From: P WARE [REDACTED]
Sent: 03 July 2018 10:04
To: Richard Castro-Parker
Subject: Objection to Proposed Planning Application - AW/129/18/HH - 20 Aldwick Gardens

**OBJECTION TO PLANNING PERMISSION – 20 ALDWICK GARDENS
APPLICATION: AW/129/18/HH**

Proposed West Elevation

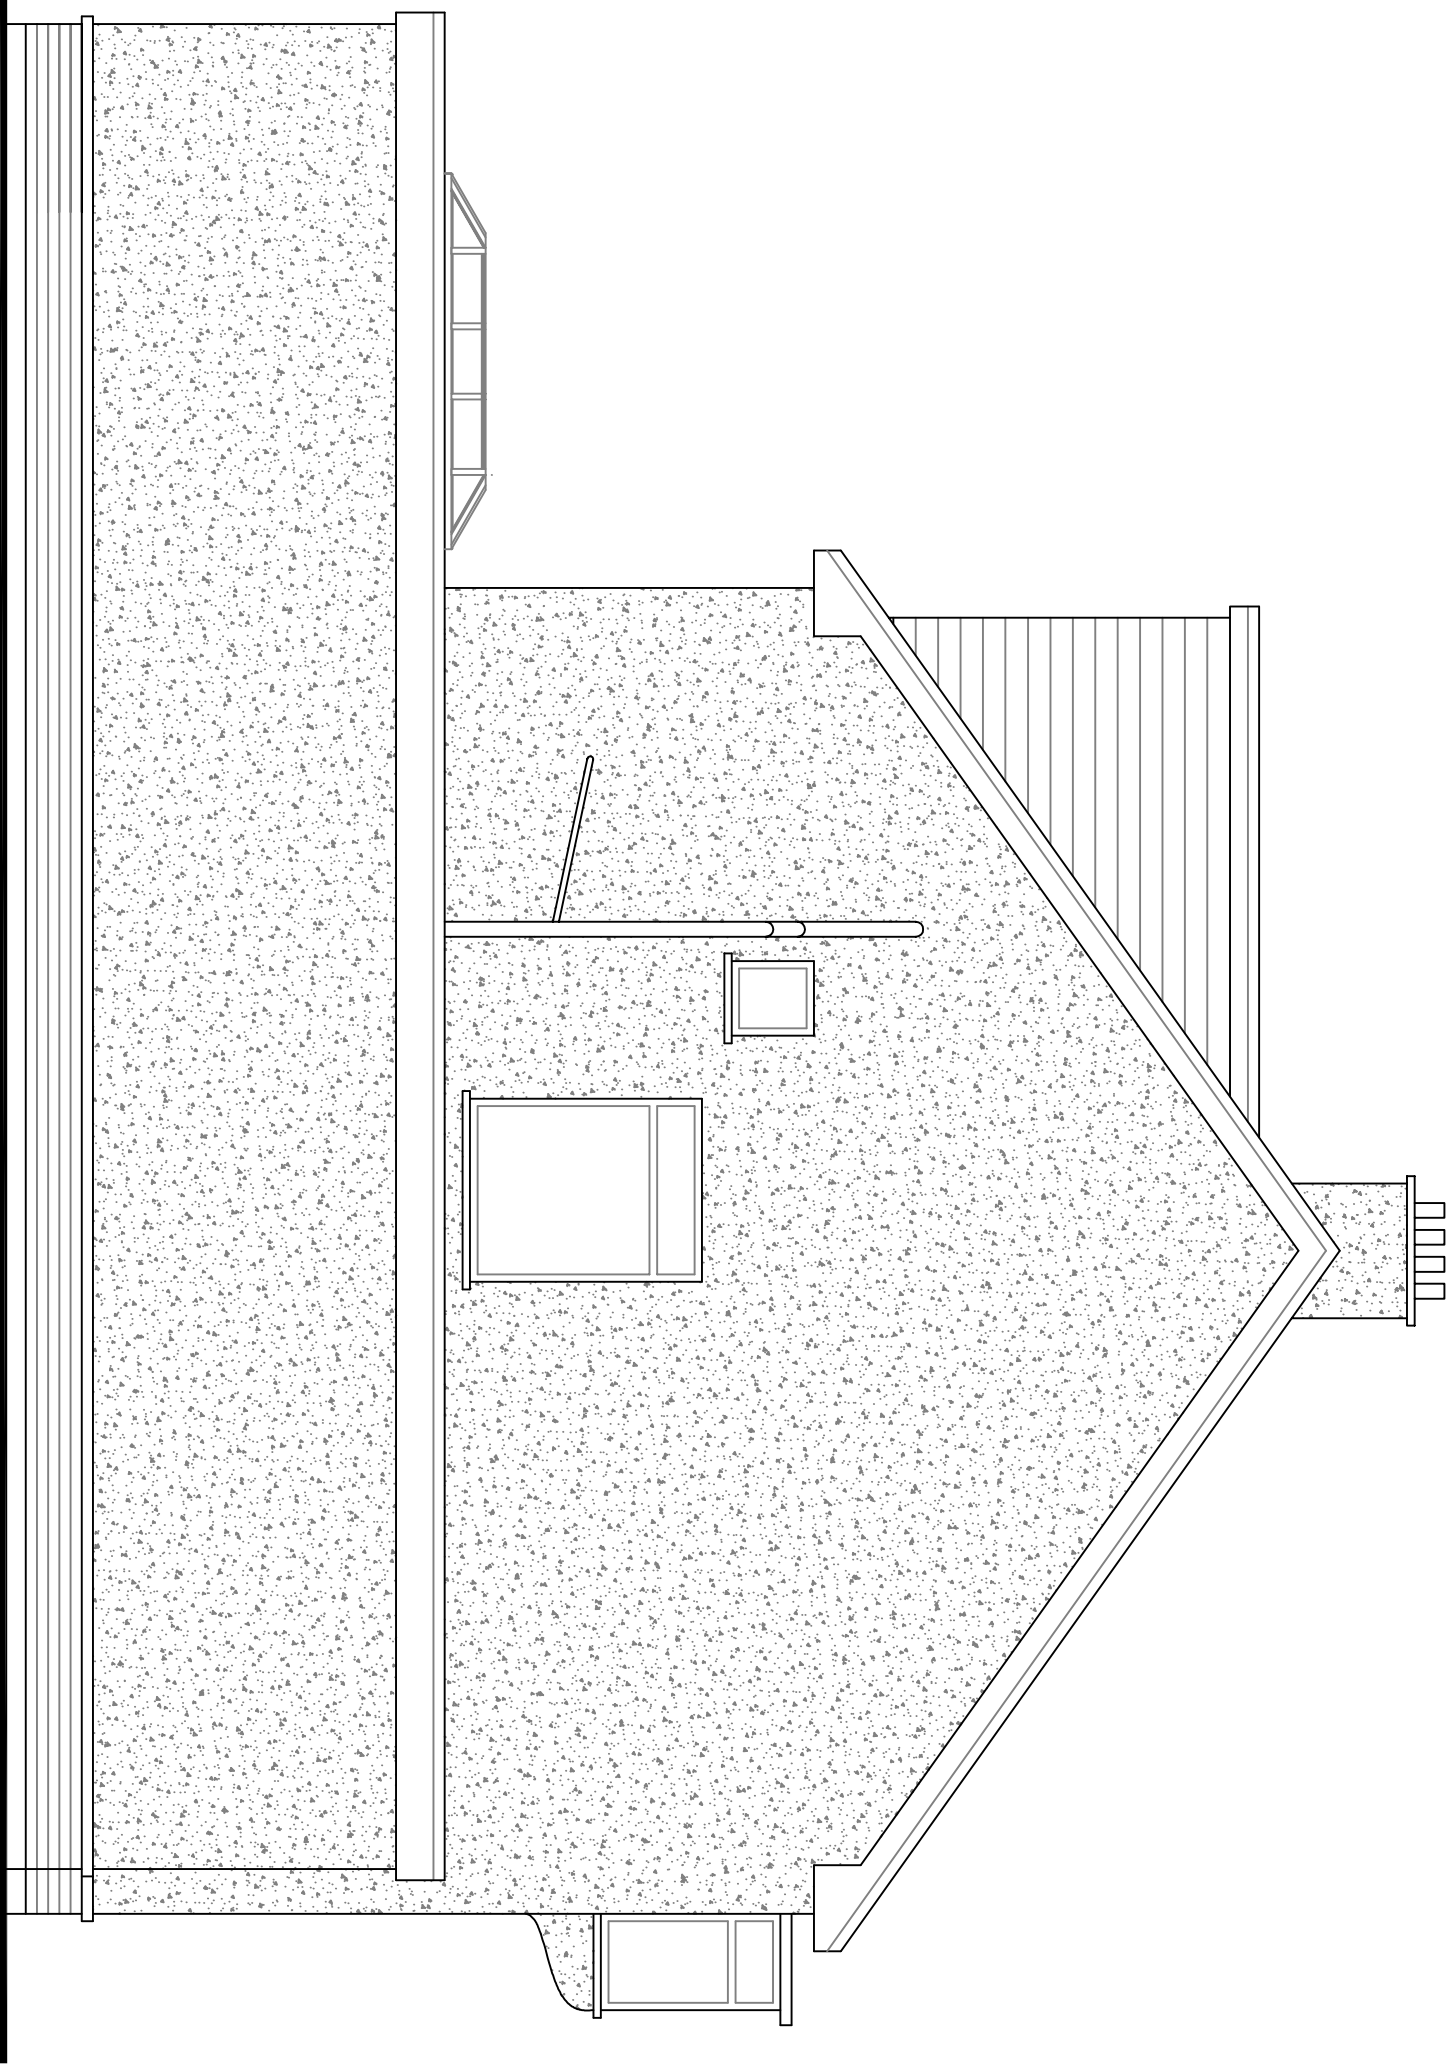
The house is at present a fairly attractive semi-detached with a standard pitched tiled roof. The proposed loft conversion will effectively make it a 3-story building as the plans show a squared off box type roof structure which looks as if it overhangs the side of the building. This proposed new roof in our opinion is completely out of character to the type of roof that exists on properties in this road, namely pitched.

As owners of the bungalow next door (no 22), the new construction will tower over our home and garden, invading our privacy and also restricting sunlight at times of the year.

Proposed Ground Floor Plan

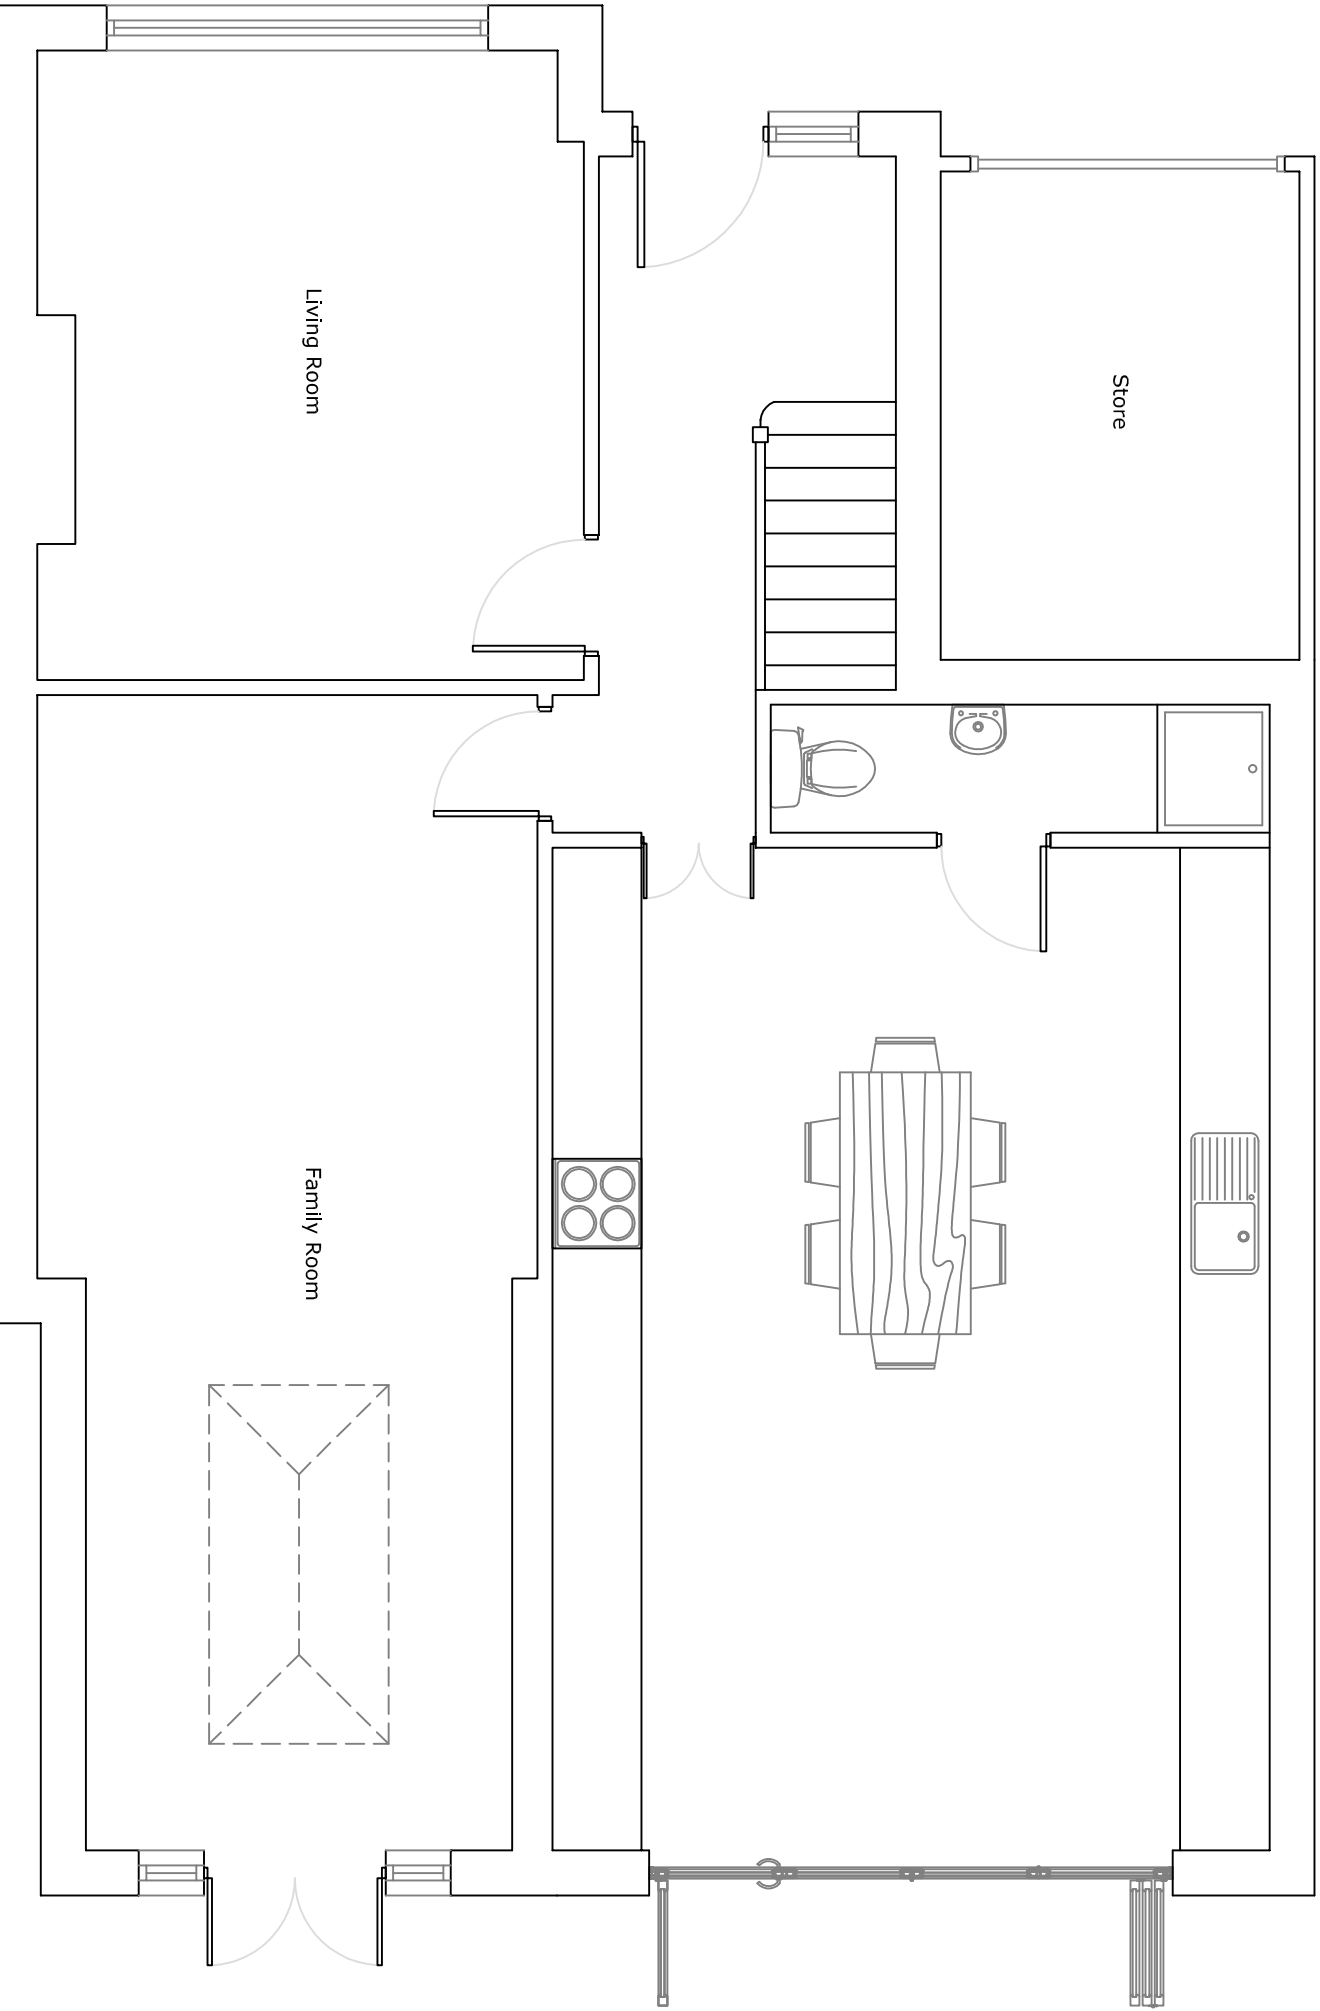
The proposed new ground floor extension will wrap around the whole of the ground floor extending out to the border of our property. The extension includes double bi-fold doors to the garden which will be right next to our property and so any noise inside their house will be exacerbated. The proposed ground floor extension will hugely increase the square footage of what should be a semi-detached house.
